FW: SUB19-002 (SEP19-005/Requirement For No Onsite Open Space/Lack of Tree Regulation)

Subject: SUB19-002 (SEP19-005/Requirement For No Onsite Open Space/Lack of Tree Regulation)

This is the application for a long plat on the old Boys and Girls Property the MI school dist. donated to the BGC in 1984 for recreation. I have a post on ND addressing this.

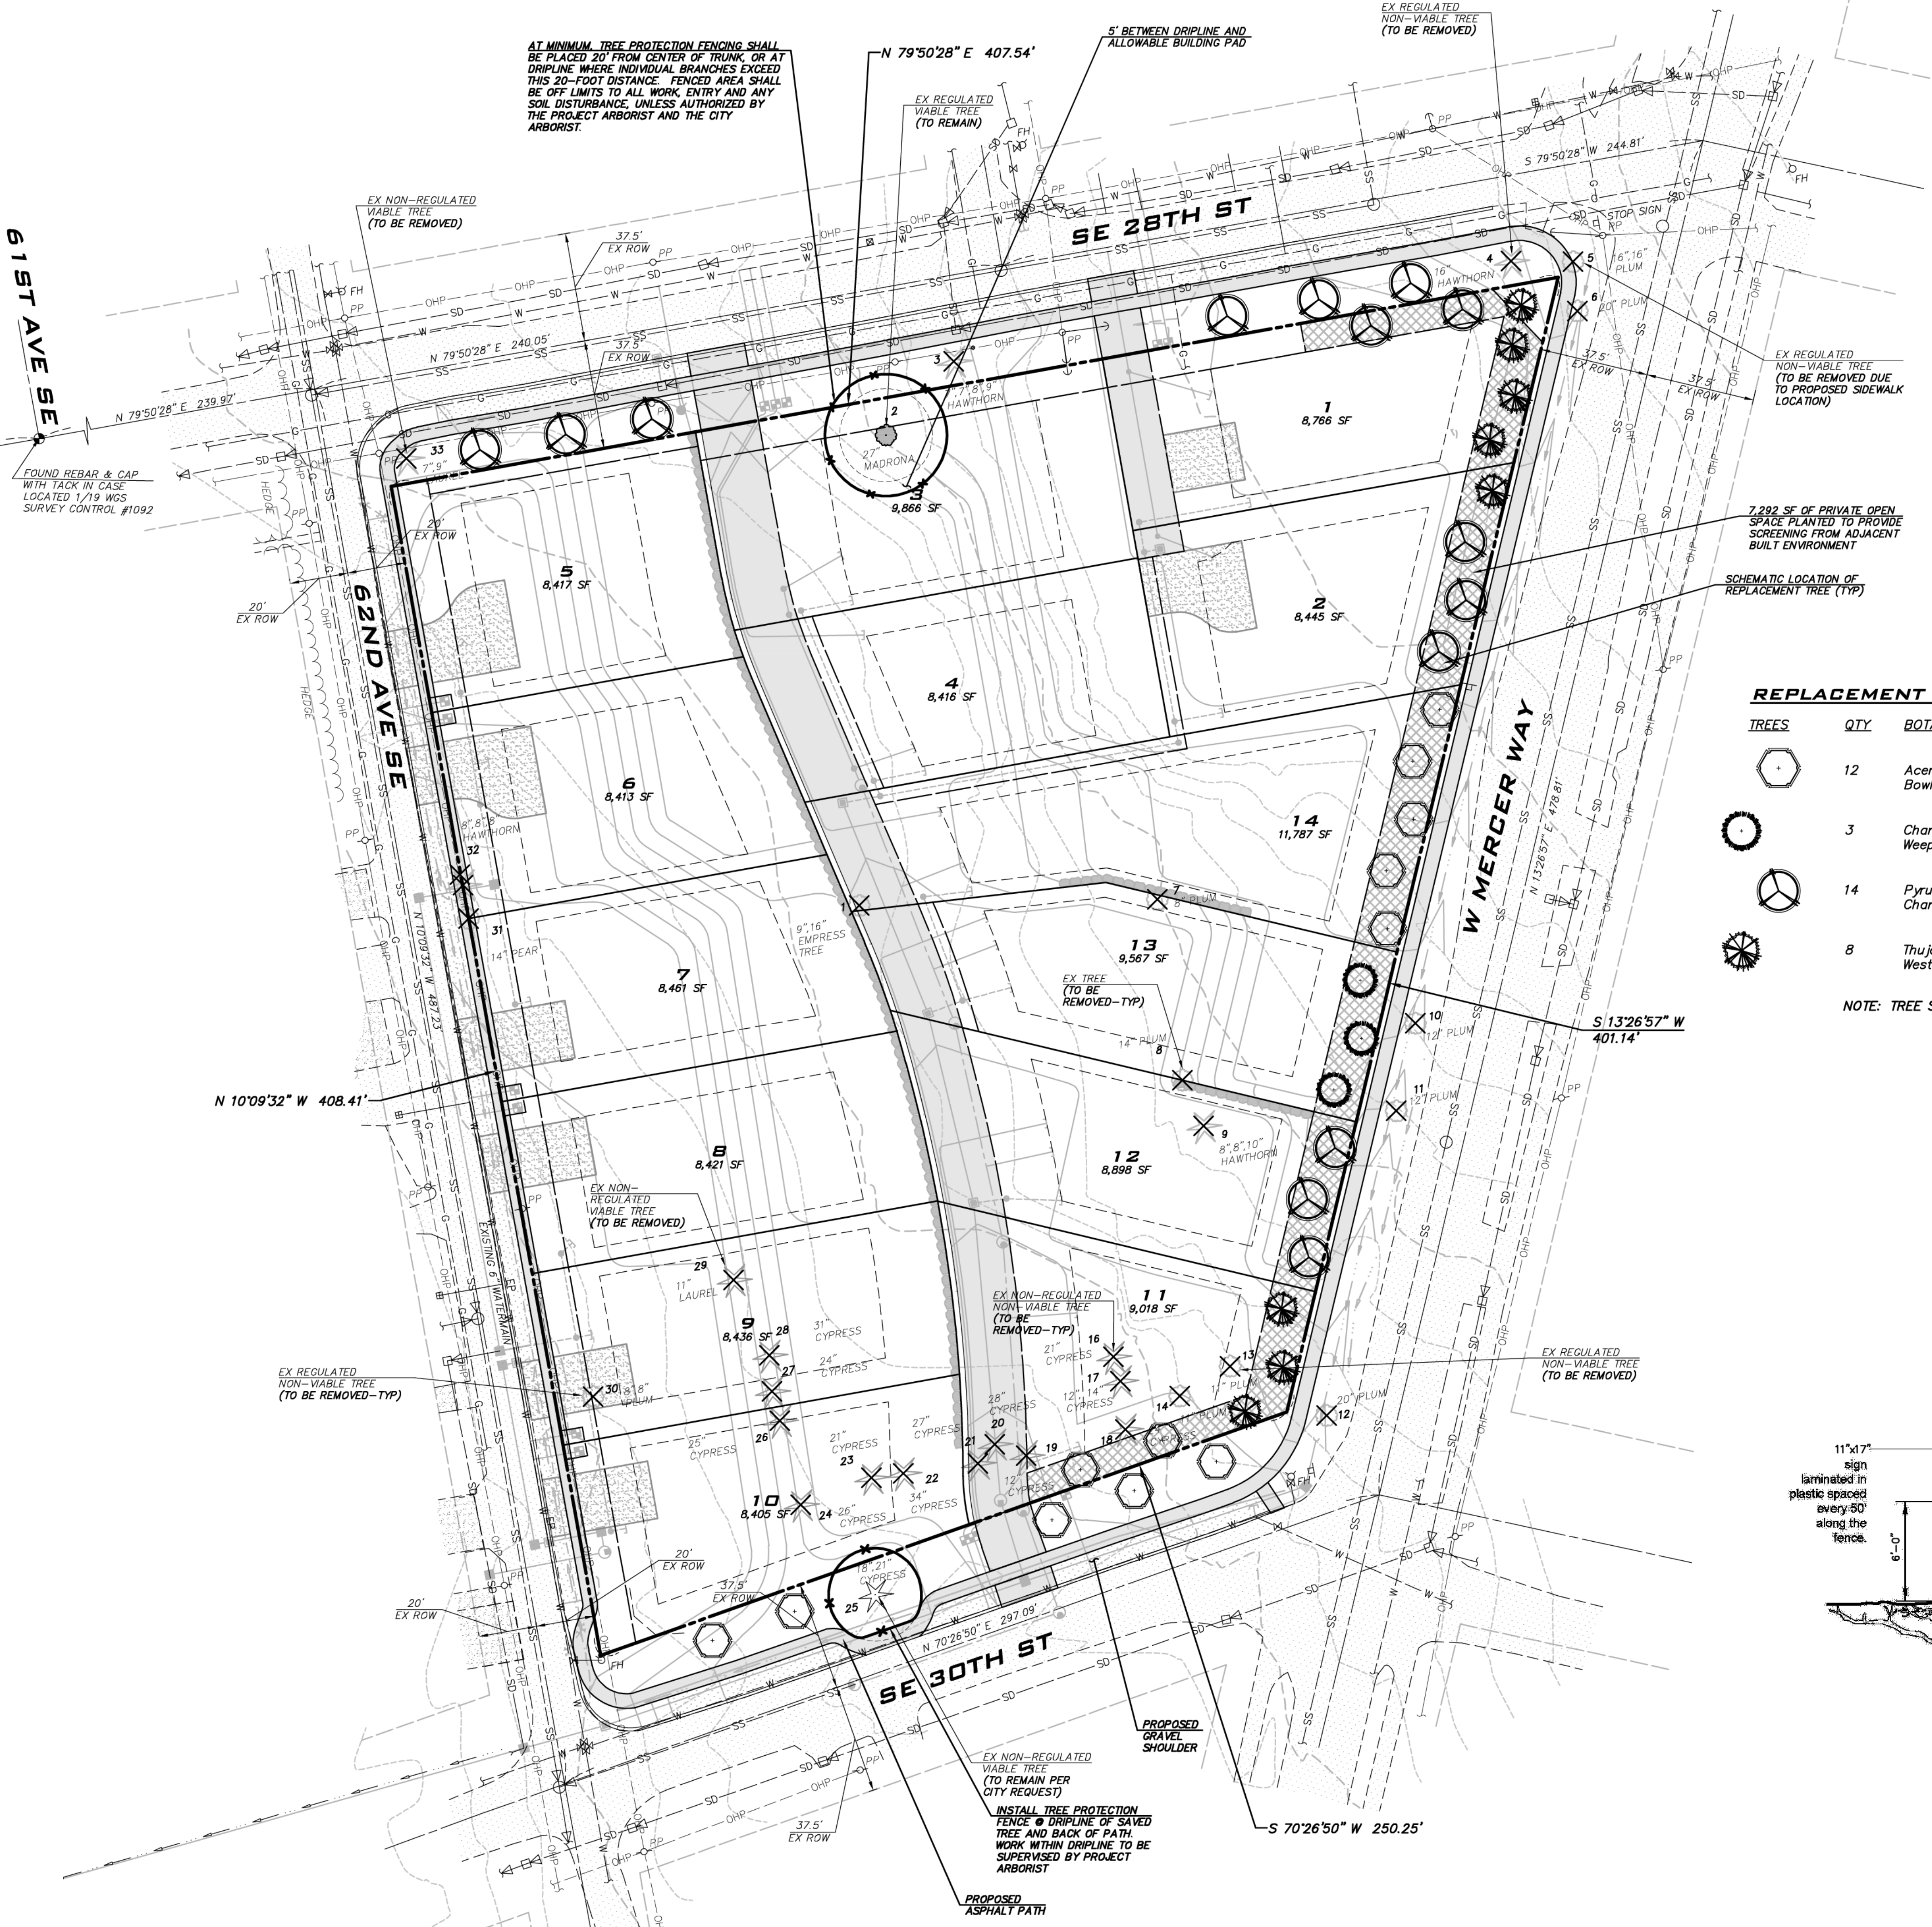
I also address in my recent reply post Harriman's approval to remove 36/37 trees, 17 the applicant claims are regulated when most are over 20" in diameter, are suddenly diseased, when the applicant's 2019 arborist report never mentions any disease.

Some of us, including Mark Coen and Carolyn Boatsman, spent years fighting for a tree ordinance against a planning commission that was adamantly opposed to any tree protection, that in the end Wendy Weiker, Debbie Bertlin and Dan Grausz watered down before adoption in 2017. But it did contain one key thing: a developer when building a house could not remove every tree on the lot because it was easier or cheaper, and each tree would be "regulated", which meant subject to permitting and inspection before removal during development. Now, instead, even BEFORE any building applications are received for the houses on each lot, the city and this planner are giving the developer a green light to remove 36/37 trees from the entire site without any city review, exactly what we fought to prevent, and what the code prohibits.

PRIVATE OPEN SPACE EASEMENT

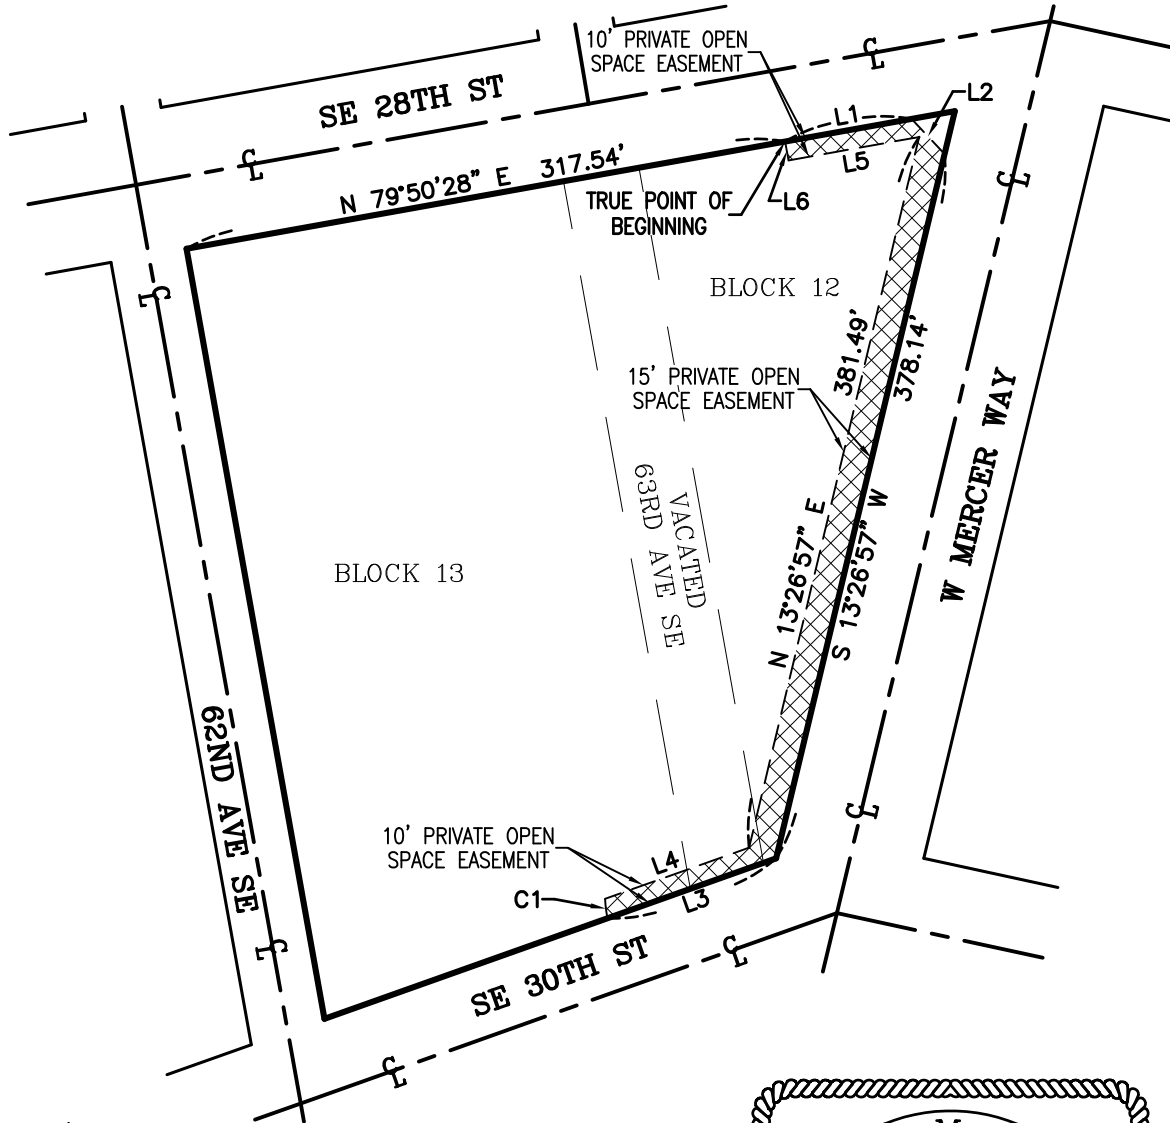
"Staff Finding: The proposed development makes a provision for open spaces in the form of a private easement for passive open space (Exhibit 5). The MICC does not provide a numerical standard with respect to the level of appropriateness as to the provision of open space".

"Staff Finding: By providing walking access along the West Mercer Way frontage to the Secret Park, the Applicant provides access to existing open space and recreation facilities sufficient to serve the proposed subdivision".

I have never heard of something so absurd. The applicant's "open space" is based on an existing city park accessed by the required setback. Because the planner claims that, *"The MICC does not provide a numerical standard with respect to the level of appropriateness as to the provision of open space"* the planner interprets this to mean zero open space without addressing the requirements under R.C.W. 58.17.020. **Is Jeff Thomas really rewriting state law and the MICC to hold a 14-lot long plat requires no onsite open space, or this is the intent of 19.08? Is Jeff unaware of the Coval long plat?**

B. There was no meaningful open space available to the public, especially for a parcel that was originally donated to the BGC by the MI School Dist. to remain open and recreational space, and by the purchaser who claimed that was his intent but lied.

The KEY is the internal access road is lot area that is deducted from the total lot area available for lots, AND so is the open space. Under the original plan Evan Maxim demanded there could only be 13 lots because there would be an internal access road, AND meaningful open space for the public. The way the applicant in the most recent design adds an access road and still can achieve 14 lots is by eliminating one of the most important requirements of the MI code and state statute: open space available to the public, on a parcel that was designed to be entirely open space in perpetuity.
